Our Ref: FP/68/18/HH
Your Ref:

Town & Country Planning Act 1990 (as amended)
Town & country Planning (Development Management Procedure) (England) Order 2015
Application for Planning Permission for Works or Extension to a Dwelling

Development Loft conversion
Location Seahaven Sea Road Felpham

Elevations 1:100
Floor Plans 1:100
Block Plan 1:200
Location Plan 1:1250

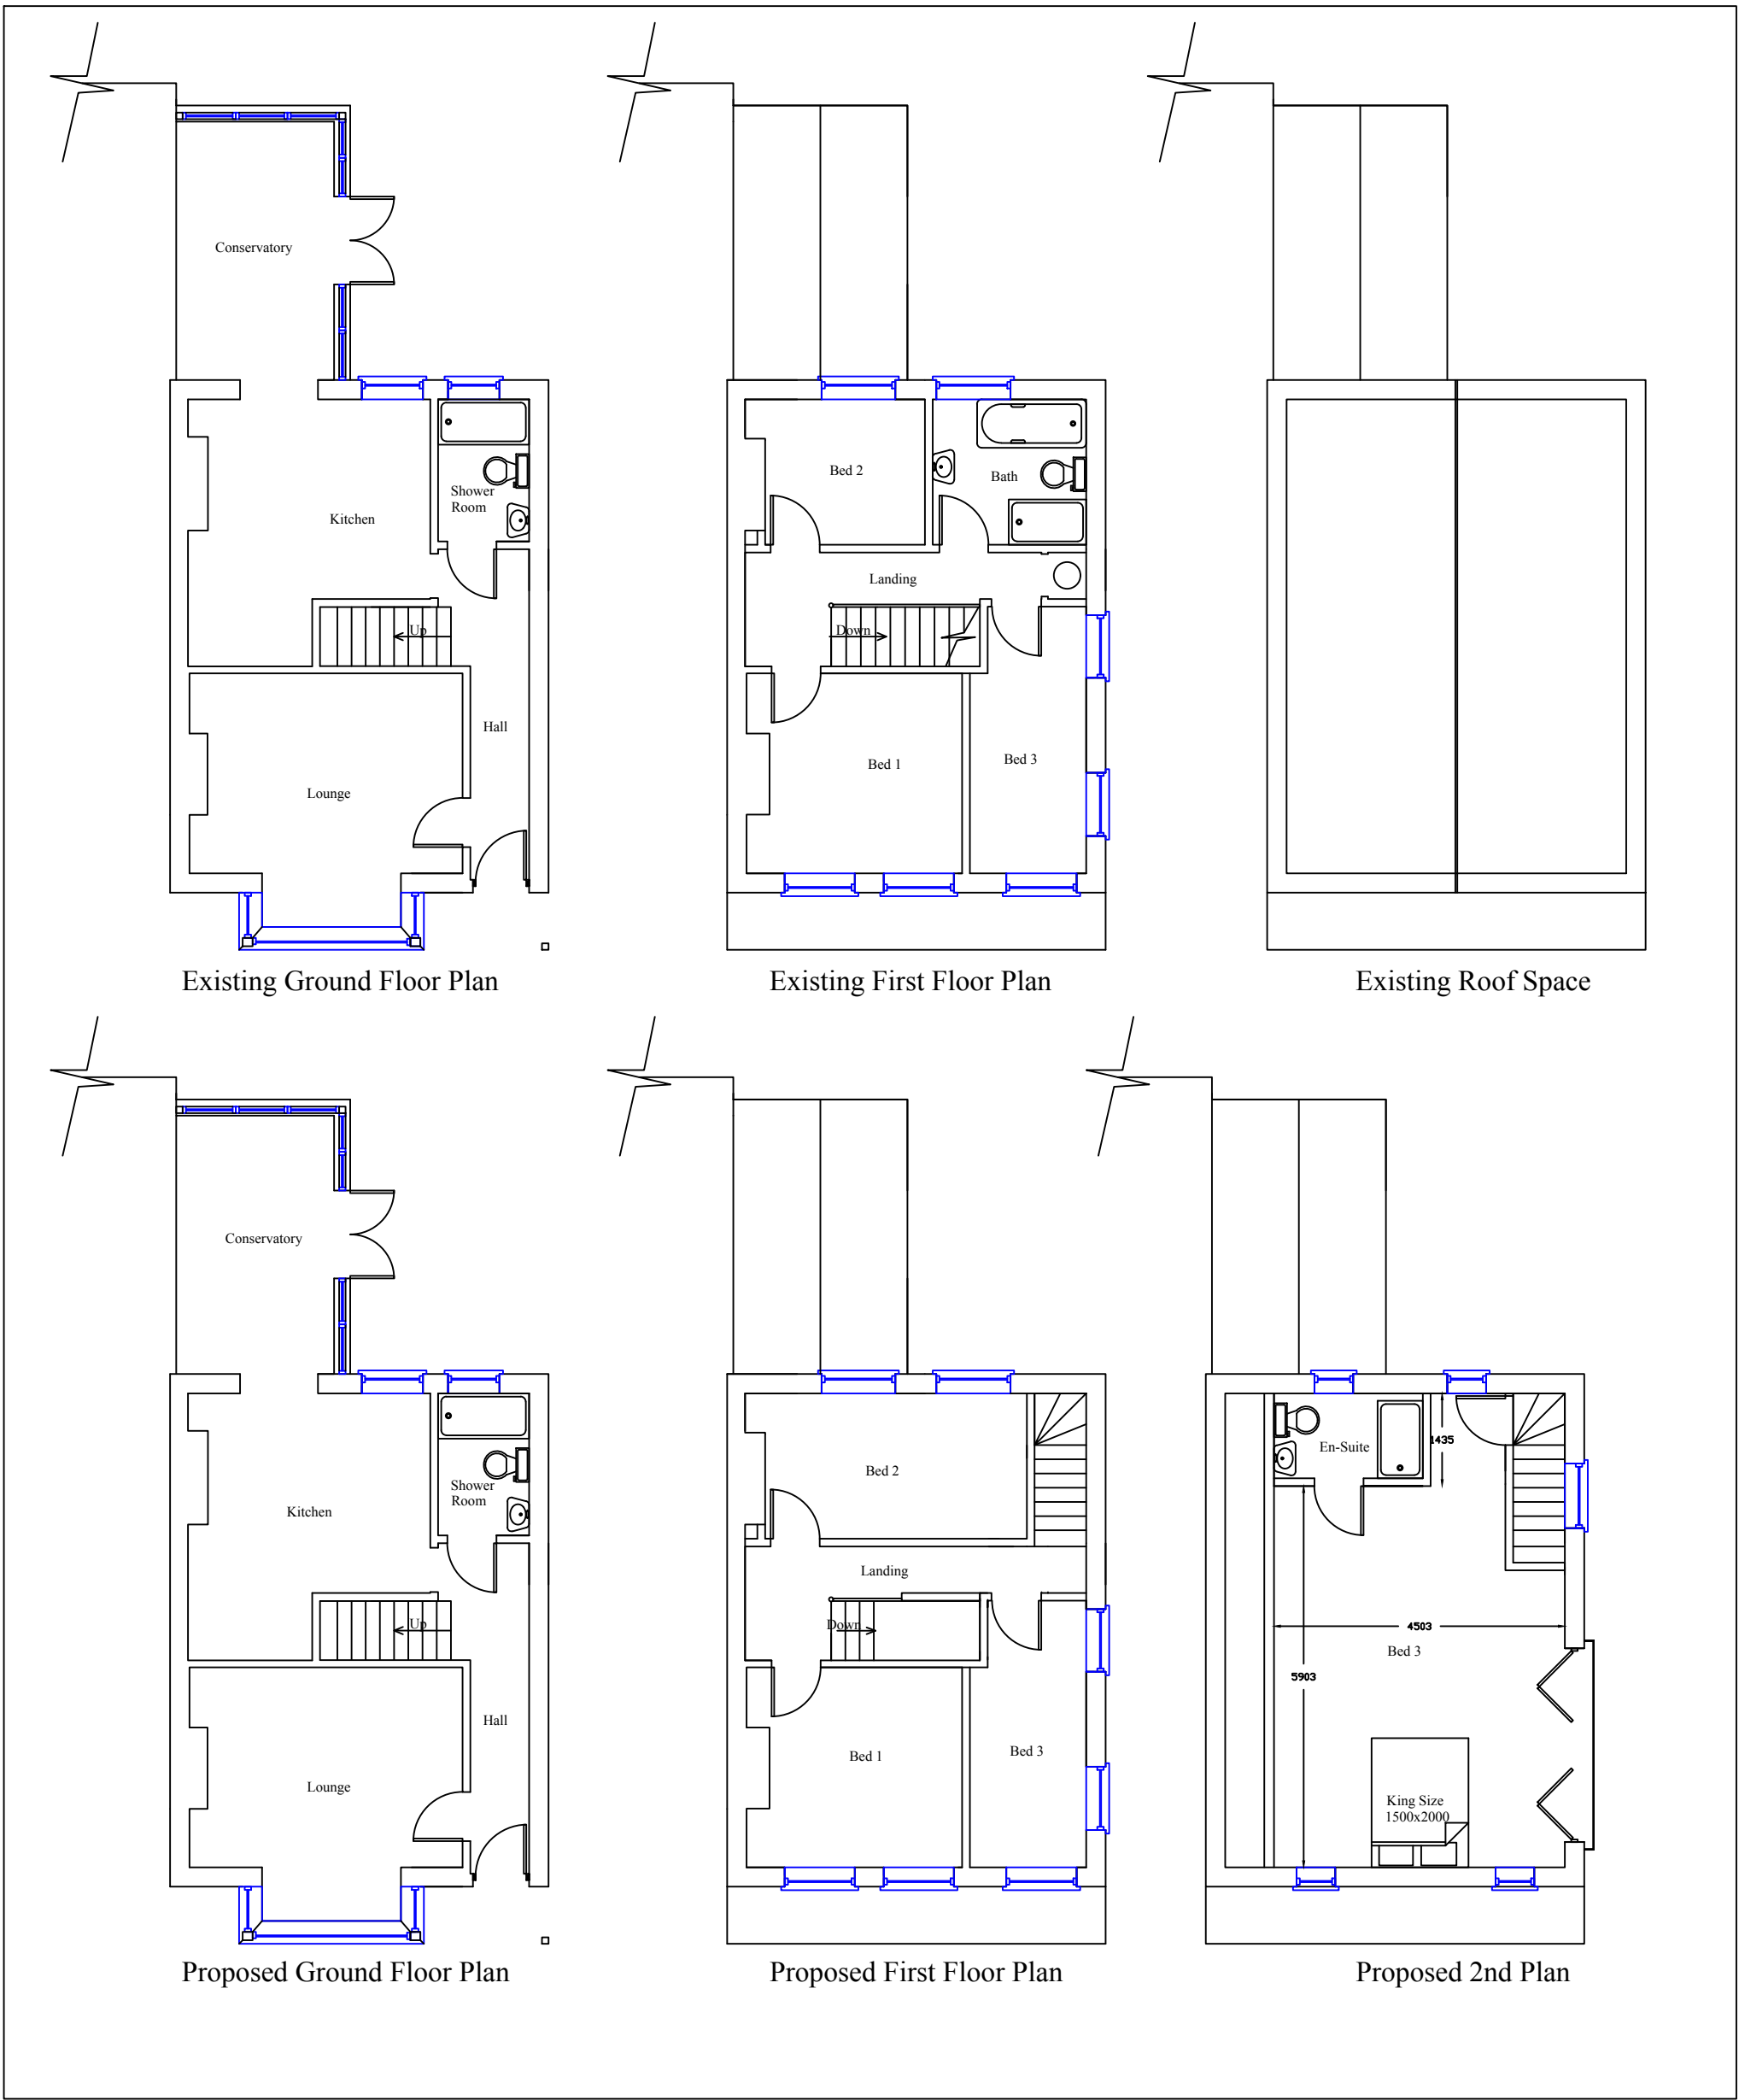
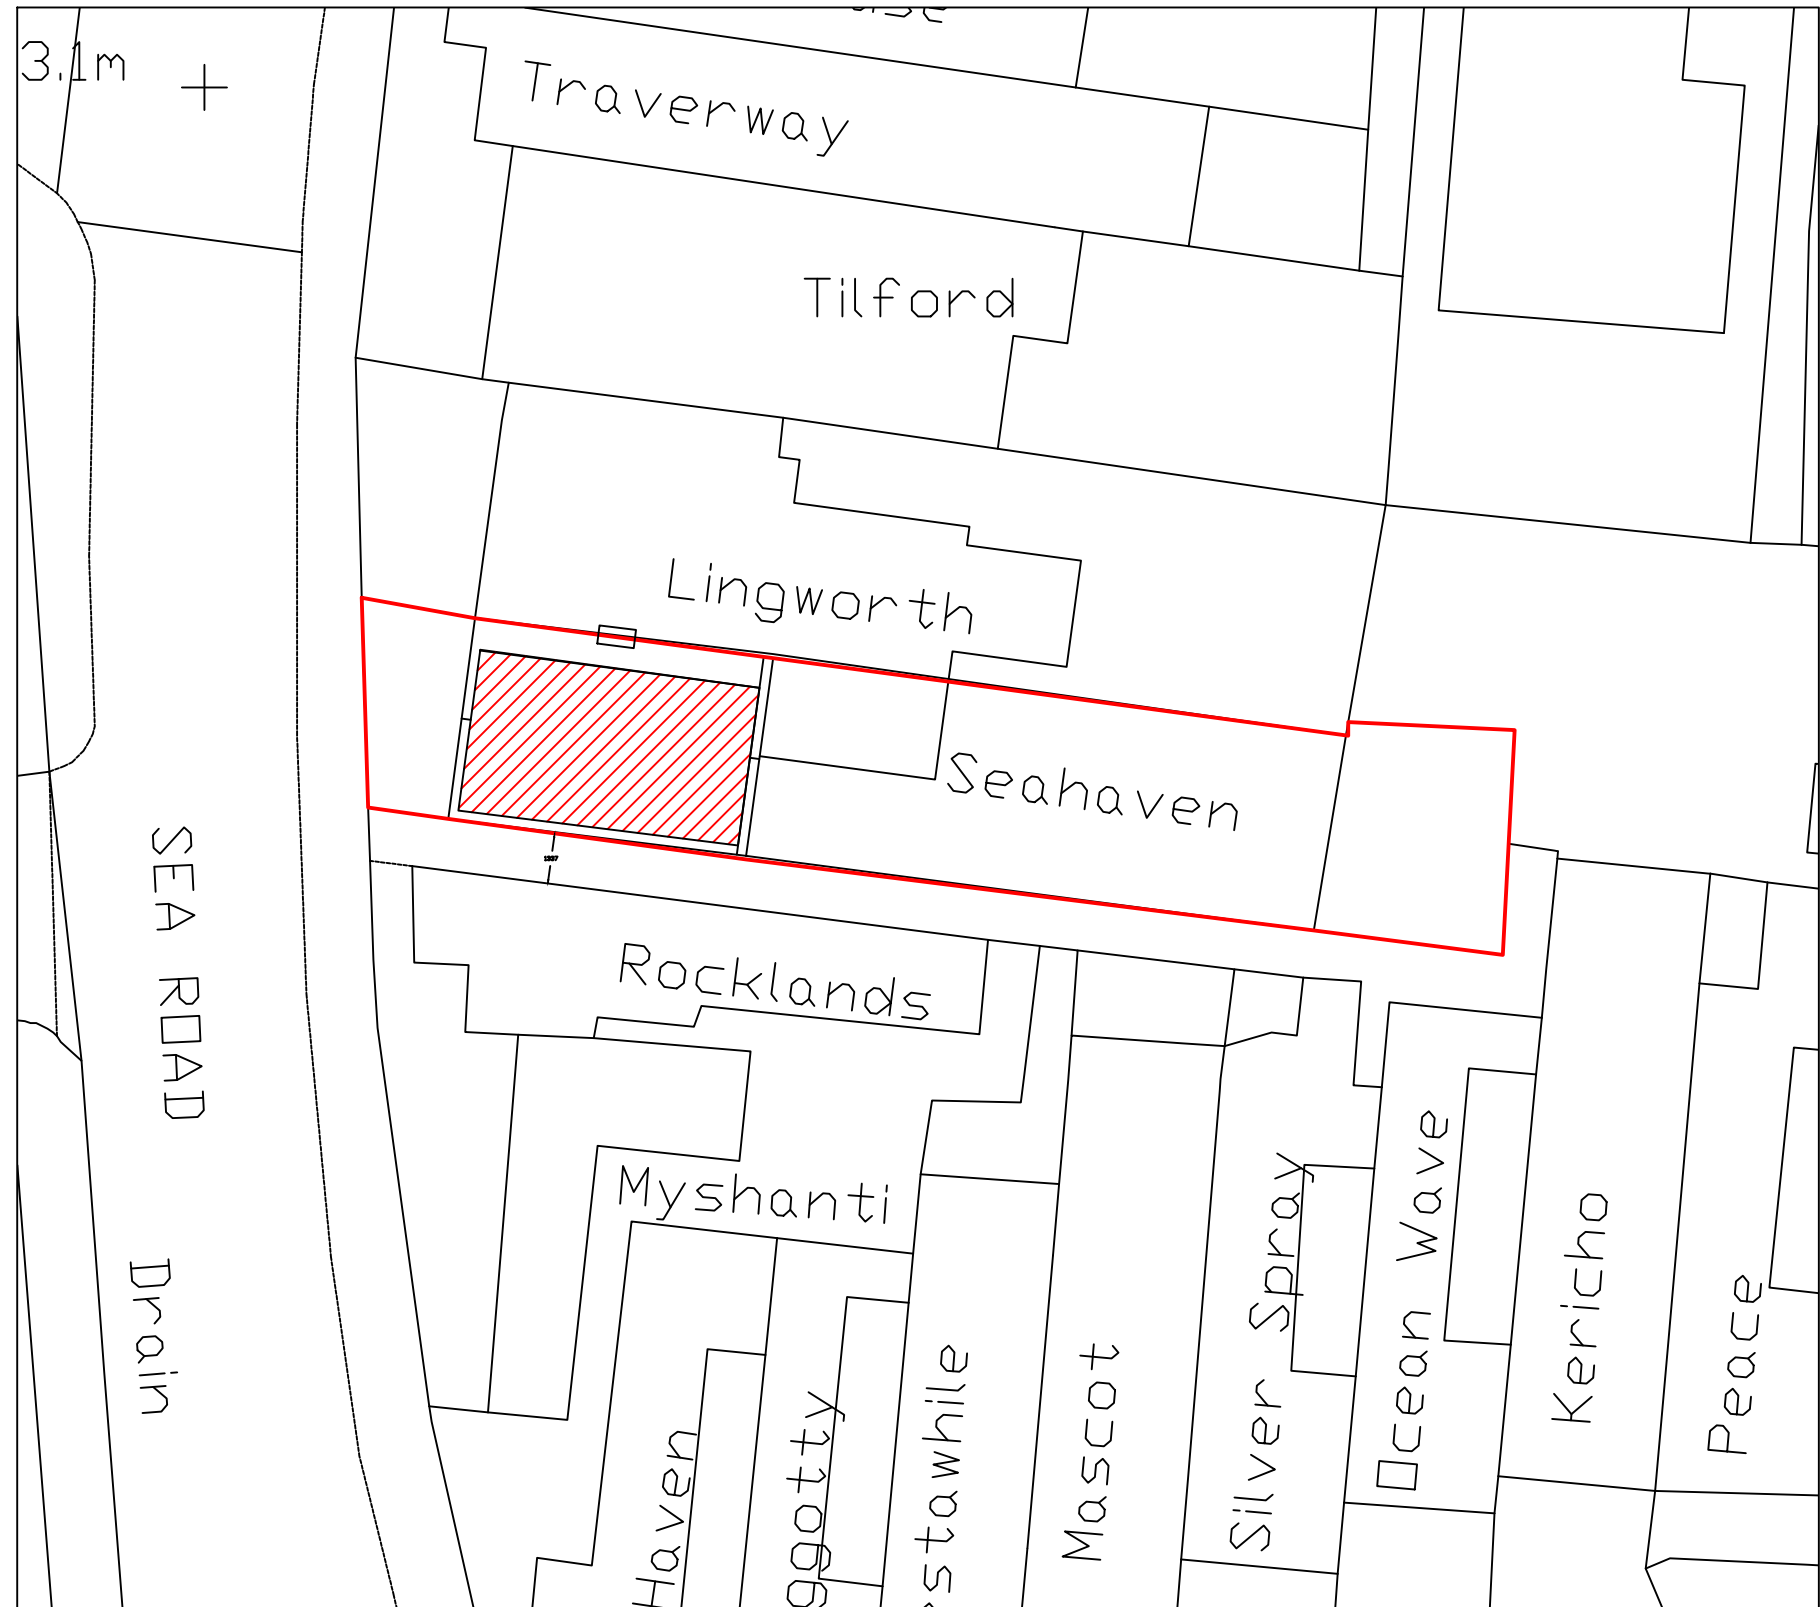
The proposed first floor and side elevation do not accord. Please amend accordingly.
